Email: ecology@lancashire.gov.uk
Your ref: CONECO/3/2012/0578
Our ref: 03/12/0578/ASM/ASP/RS
Date: 11th October 2012

Planning Application No: **3/2012/0578**
Proposals: **Development of outdoor adventure centre**
Location: **Devil's Elbow**
District: **Ribble Valley**

Ecology comments following submission of information to address potential impacts on the Heronry

drg.no. 11/26 PL 01 rev C

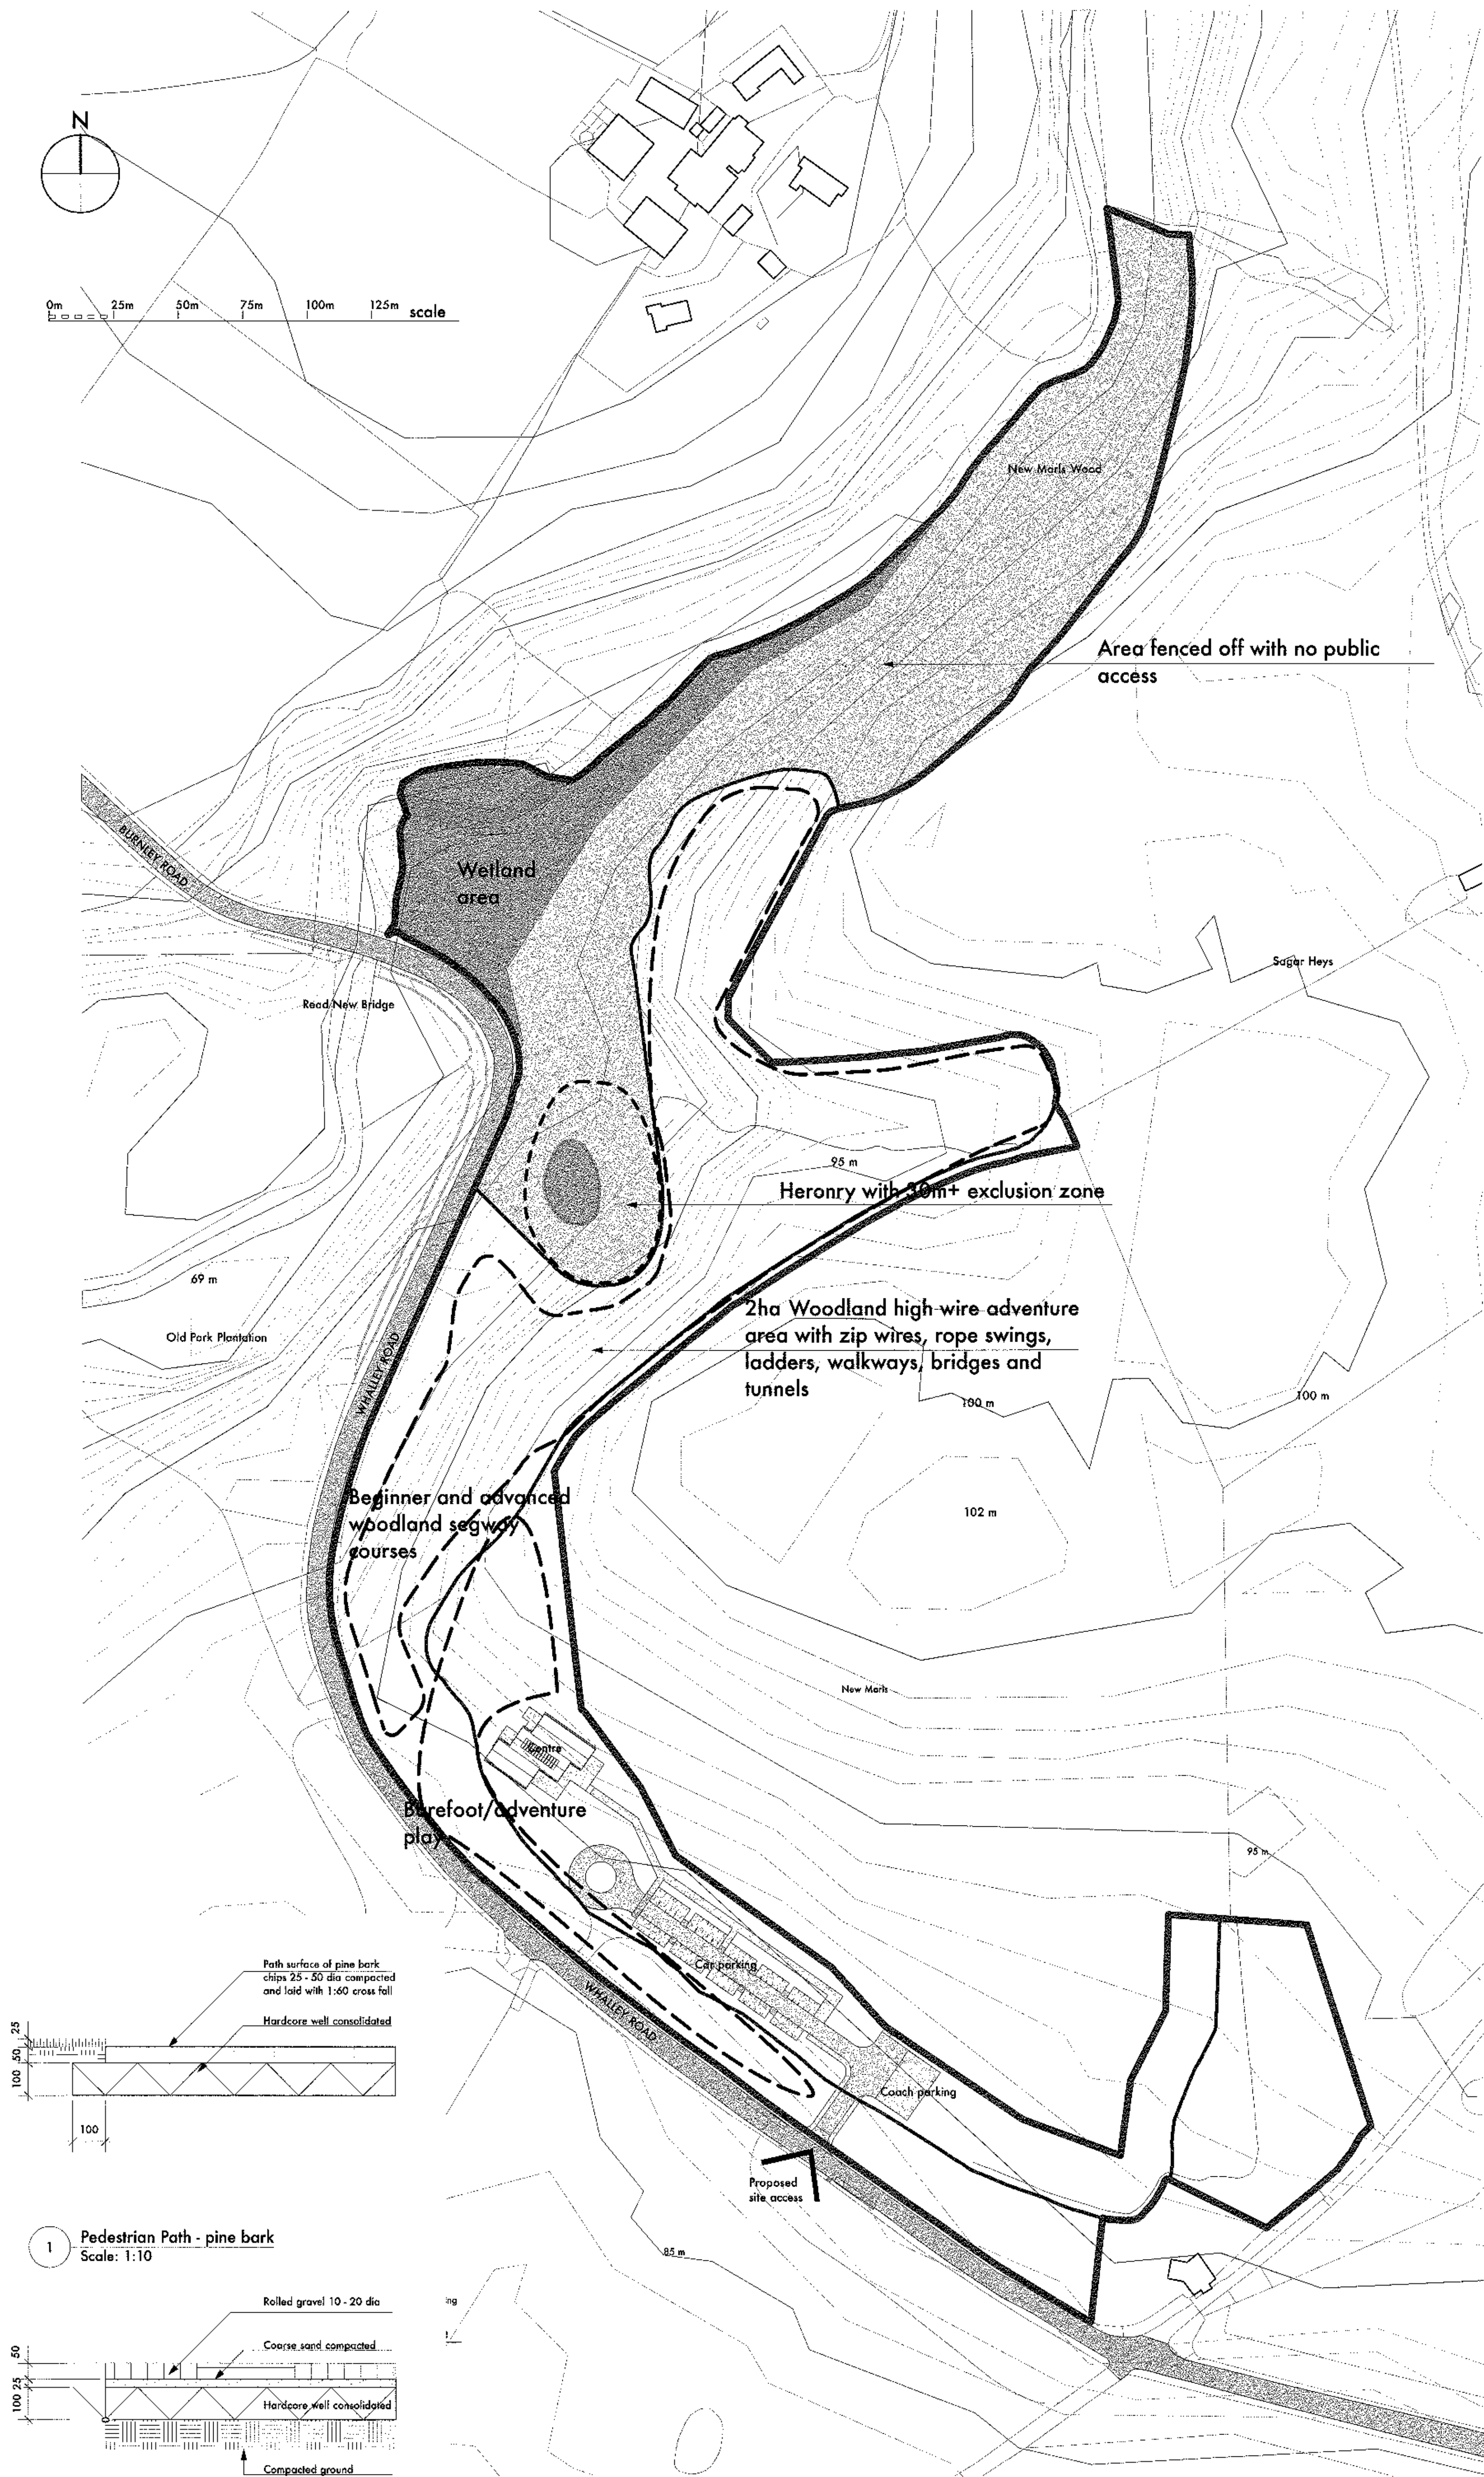
If Ribble Valley Borough Council is minded to approve the application with the recommended timing restrictions attached, then although the site plans are only indicative and a detailed route can be agreed under planning condition, the original route would be preferable for the following reasons:

- It has already been established that the original proposed aerial walkway route can be accommodated without affecting any trees that could support roosting bats.
- The likelihood of the badger sett being seen or disturbed by the public would be reduced.

The woodland supported 6 active nests in 2011 (local bird group data). The submitted revised plan plots the heronry. During a site visit I plotted the nests observed (6 in total) and it is clear to me that the heronry covers a much wider area than that shown on the submitted plan, including a nest to the north of the gully and nests further to the south, to the southern extent of the Mixed Plantation Woodland as shown on the Phase 1 Habitat map (Cameron Crook & Associates, June 2012).

- There shall be no disturbance associated with the development, including construction works, site maintenance, site operation/recreational activity and dismantling, both within the woodland and within 250m of the edge of the area of Mixed Plantation Woodland as shown on the Phase 1 Habitat Map (Cameron Crook & Associates, June

- Both the woodland and land outside the woodland within 250m of the edge of the area of Mixed Plantation Woodland as shown on the Phase 1 Habitat Map (Cameron Crook & Associates, June 2012) shall not be open to the public between January and July inclusive and until checks have been made to ensure that the birds have finished breeding.
